PROJECT #: 25-1319-A

DATE: September 22, 2025

LOCATION: 166 Hilliard Rd, Fuquay-Varina, NC

PLANS REF: Danny & Jennifer Durham Residence by K&A Home Design Project #: 25-1319

S-4

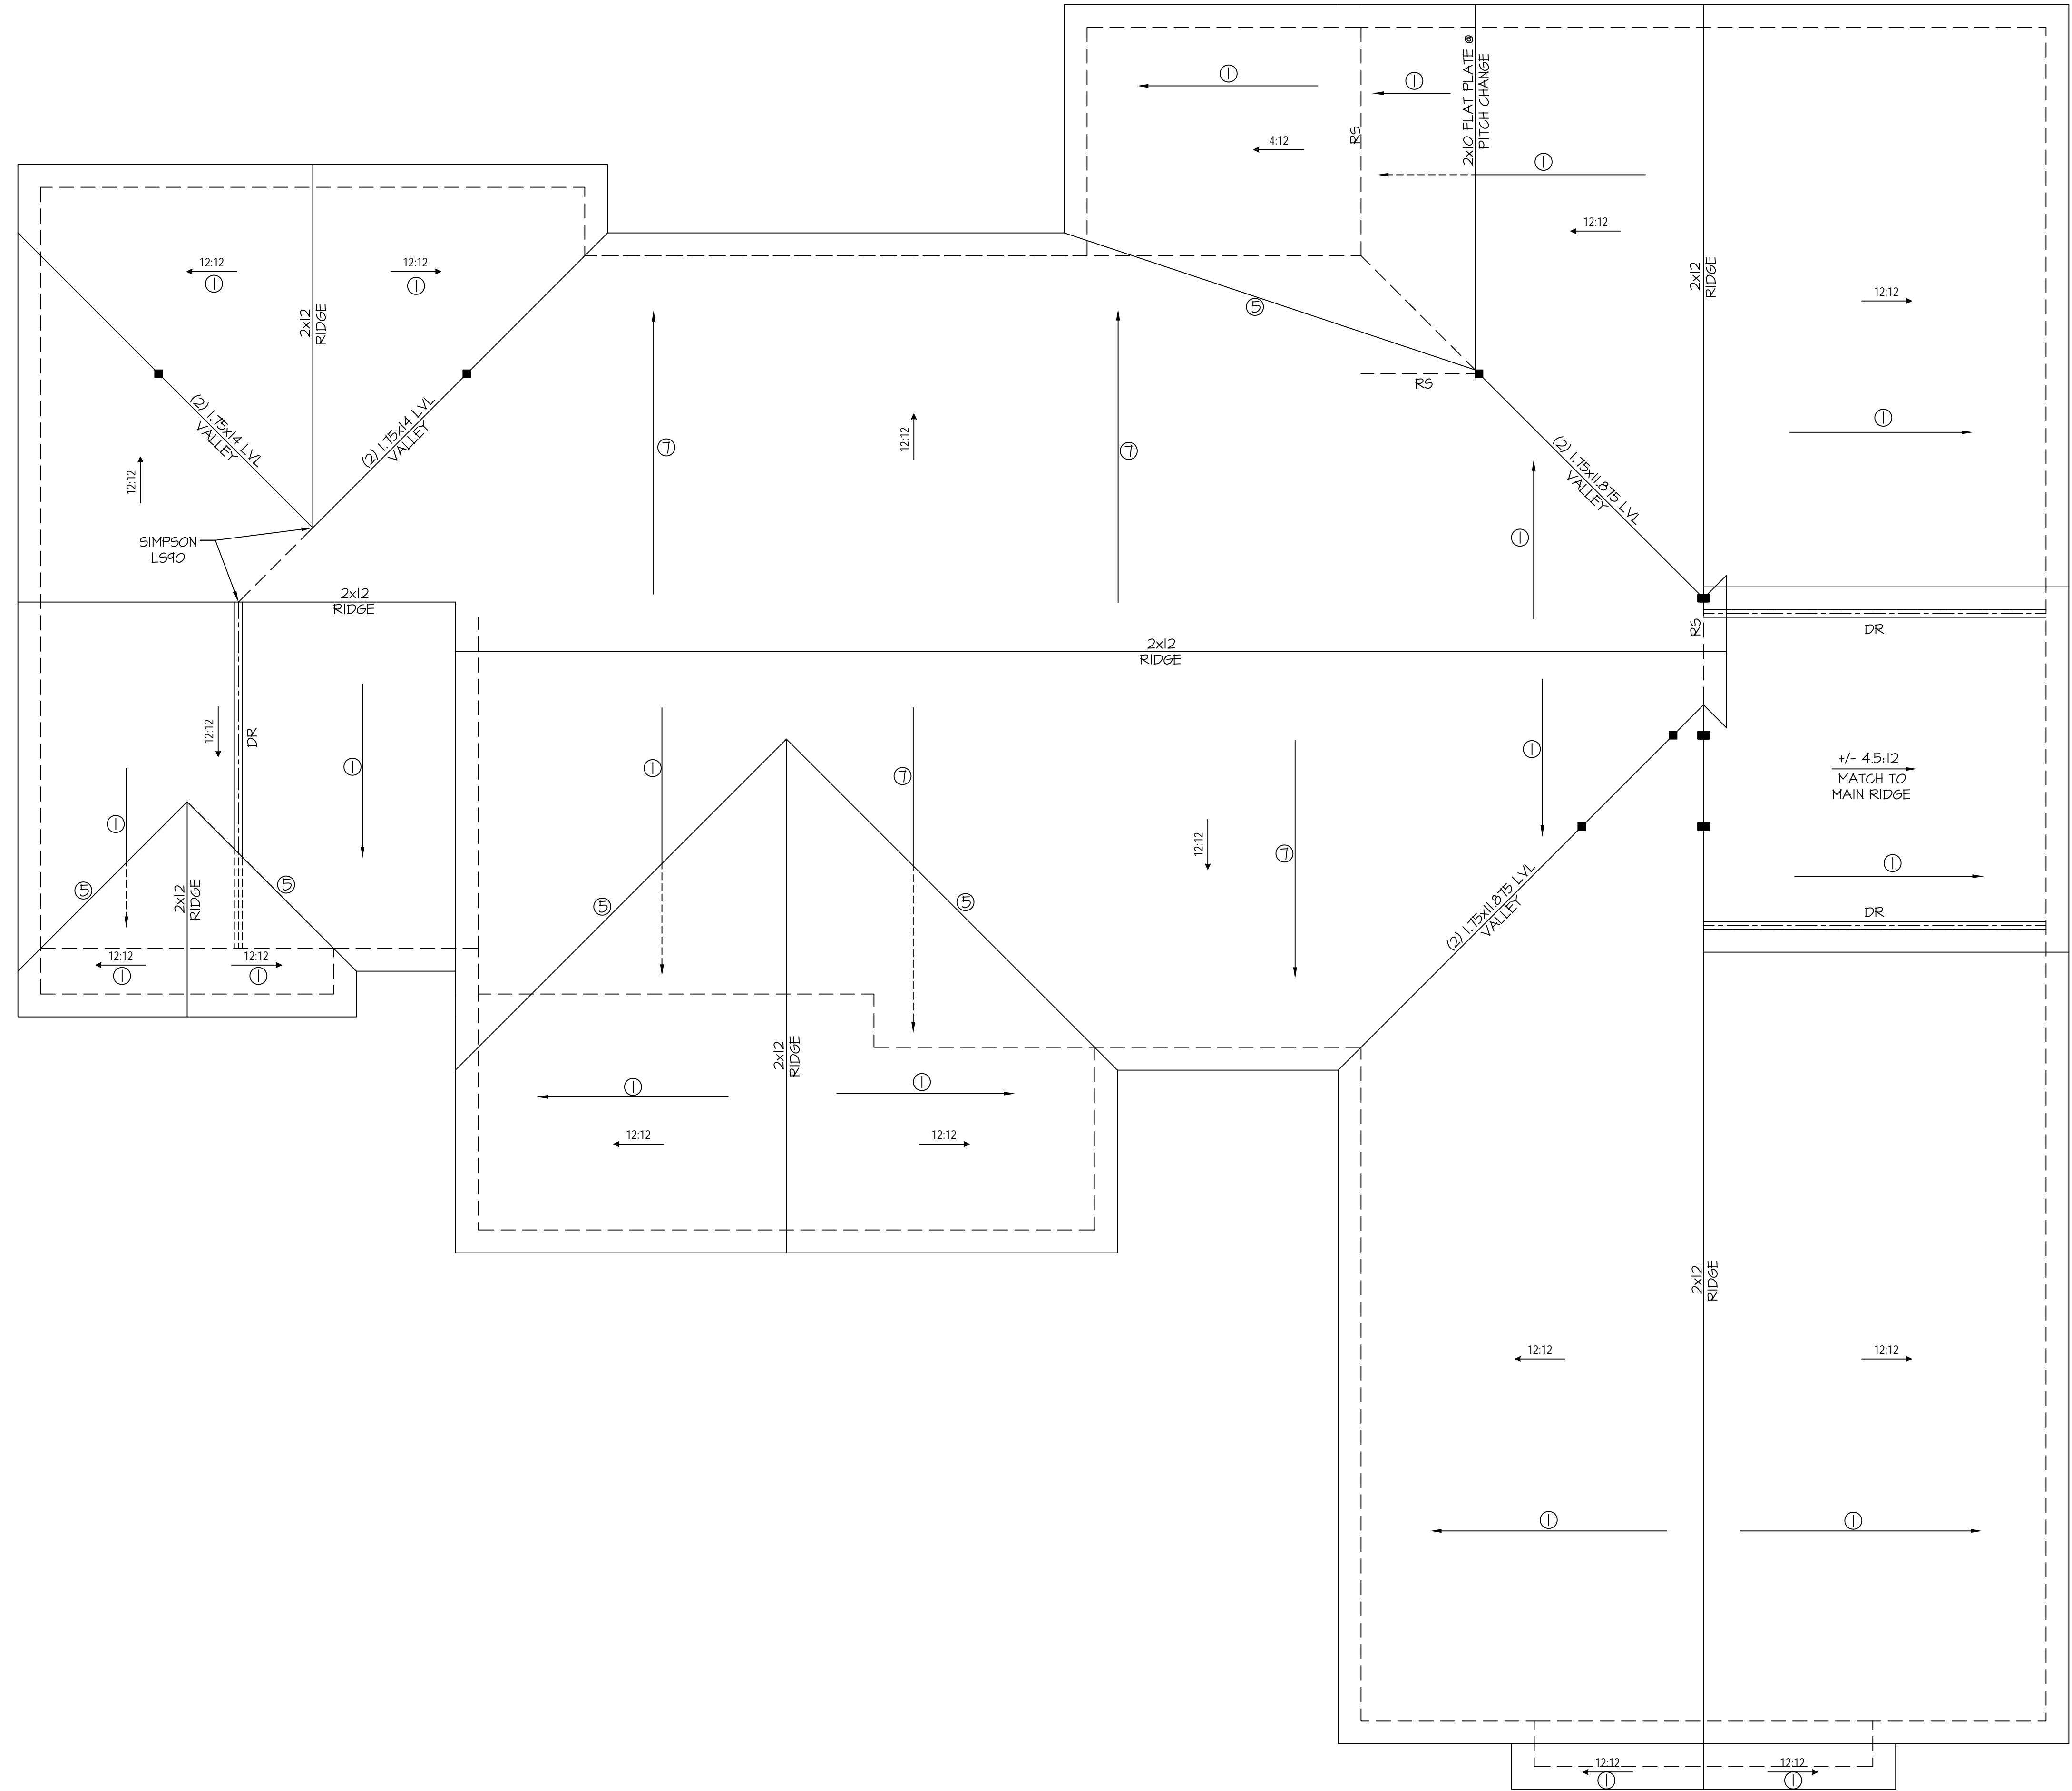
Ridge Substitution: Sheet S-4 of the plans specifies 2x12 ridge throughout the roof system. It was noted that 2x10 ridges furred down with a 2x4 was installed instead of the 2x12 ridges. Please note that the ridge substitution is structurally acceptable.
